4 No. bungalows
44 Ferringham Lane Ferring

Thank you for your internet representation made on 12th February 2018 which has been recorded as '**an objection**' with the comments as follows:

DWG No. 628-03 rev. C

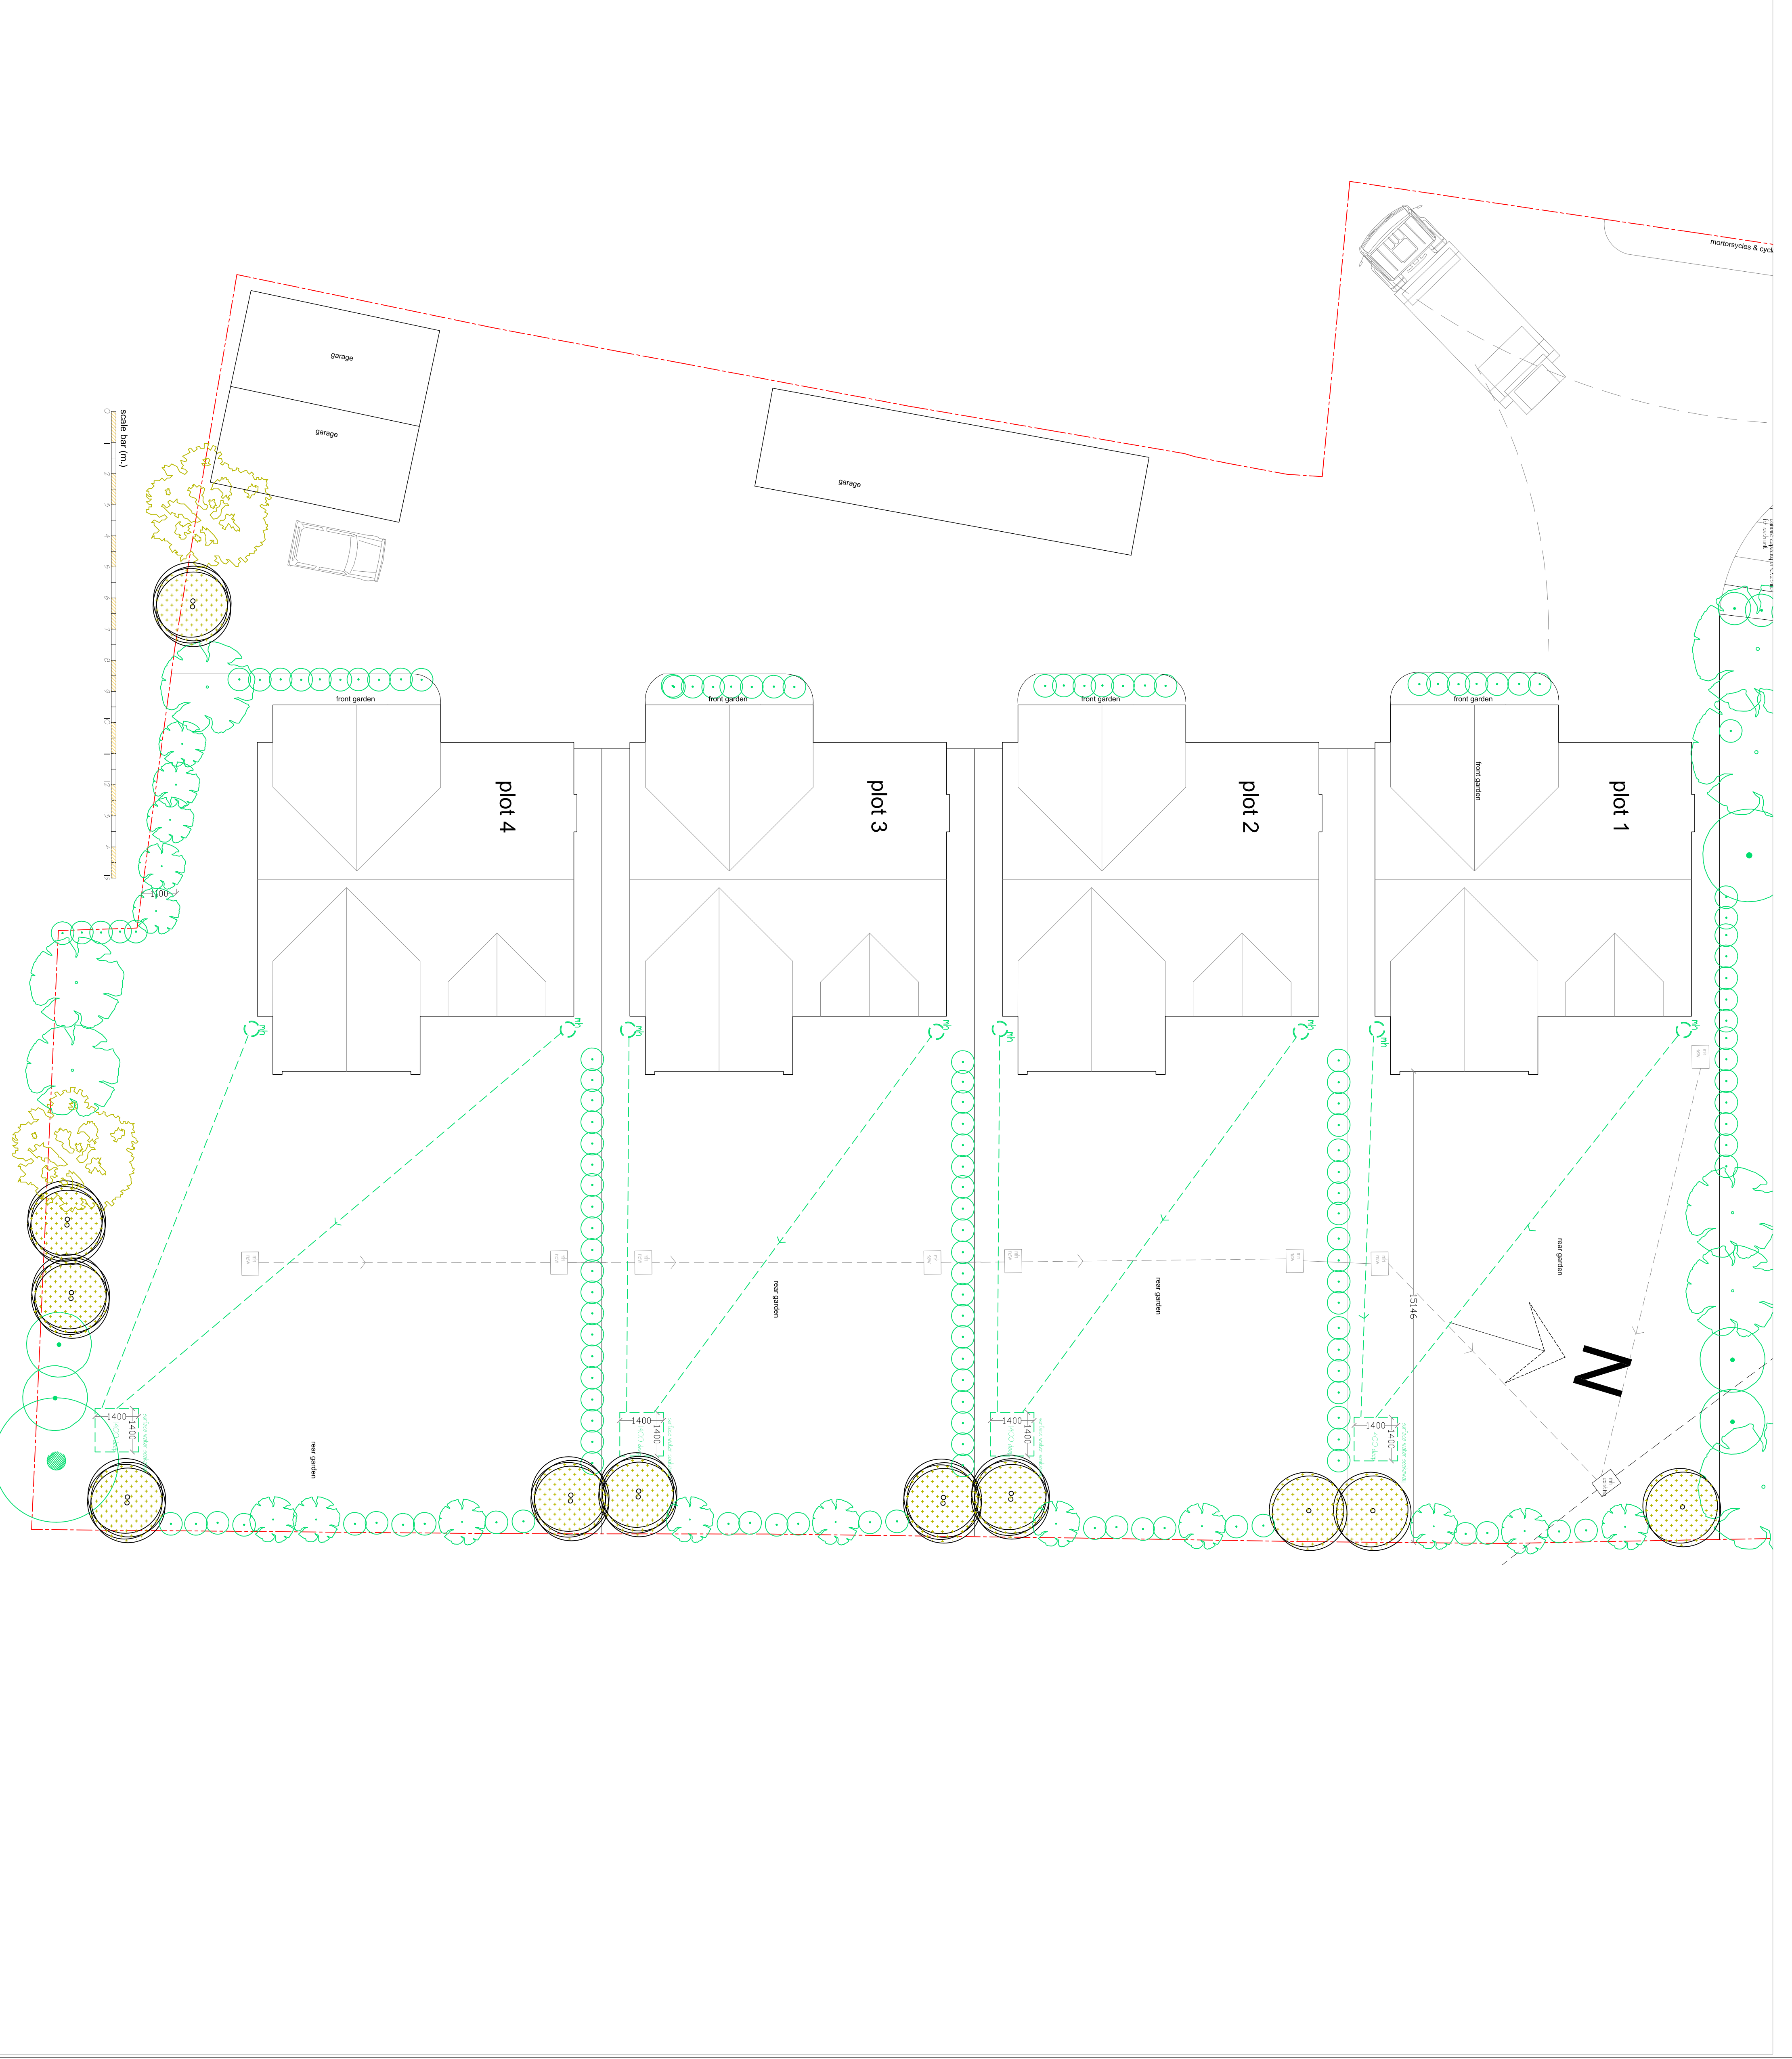
Ferring Conservation group still objects to this application. Even if the 4 metre wide access could be achieved (and in practice it cannot) it is clear from the numerous alterations to the plans that there are serious problems at the development site itself, with parking and turning. The swept path on the plan may be geometrically valid but it would require extraordinary skill to drive a large vehicle like a refuse collection lorry, or fire appliance onto the site, turn and drive out. If all the residents' vehicles were parked neatly, as in the diagram, again it might be theoretically possible to manoeuvre in this way - but this is very unlikely to be the case, and it takes no account of delivery vehicles.

Site section (east-west)

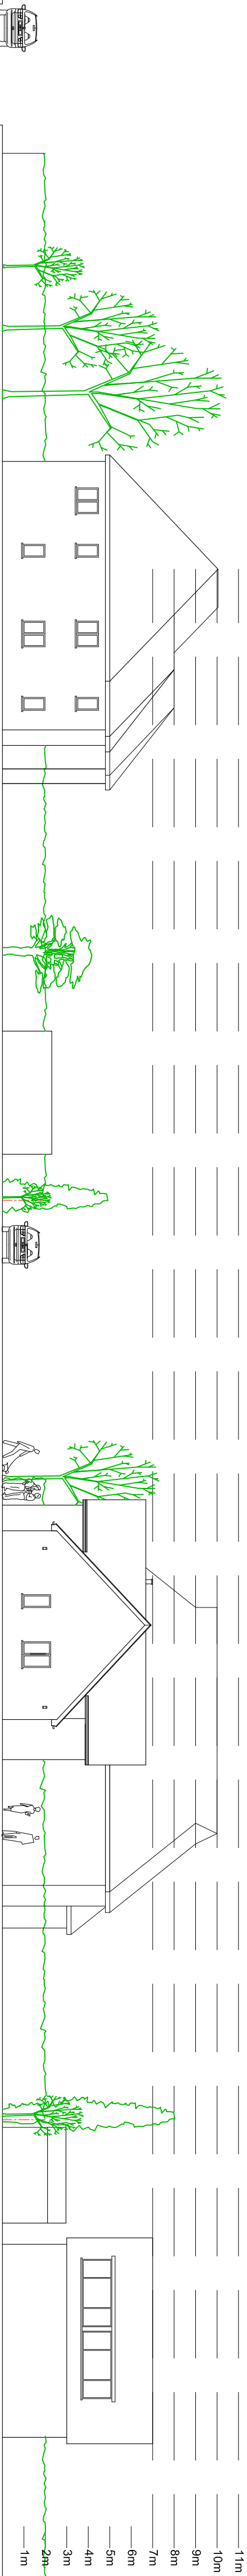
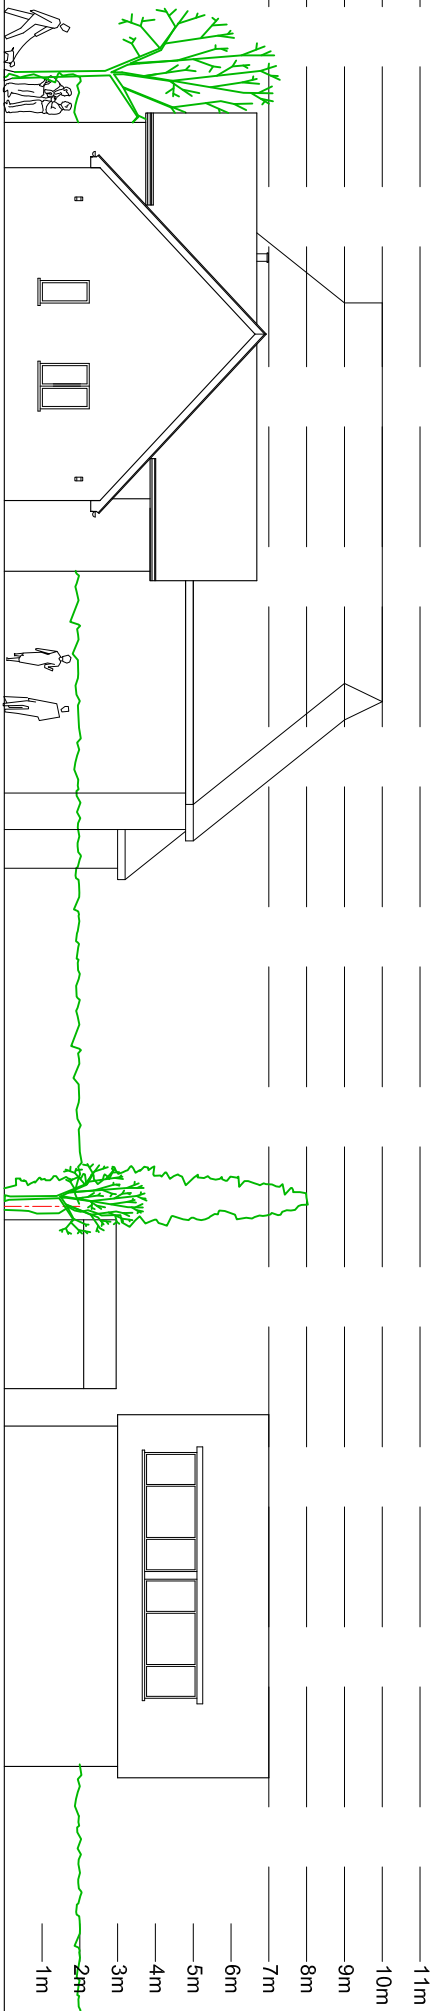
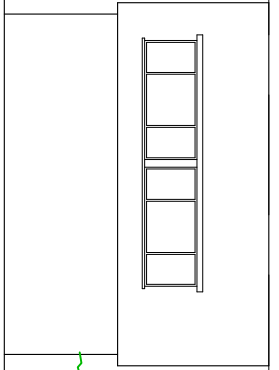
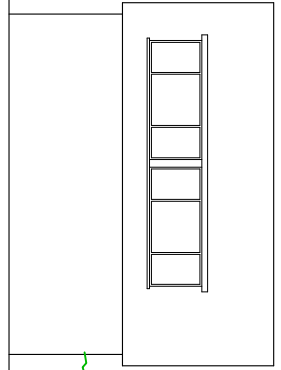
The dwelling themselves are too large for the plot - overbearing and overlooking their neighbours in Little Paddocks. These are large houses, not bungalows.
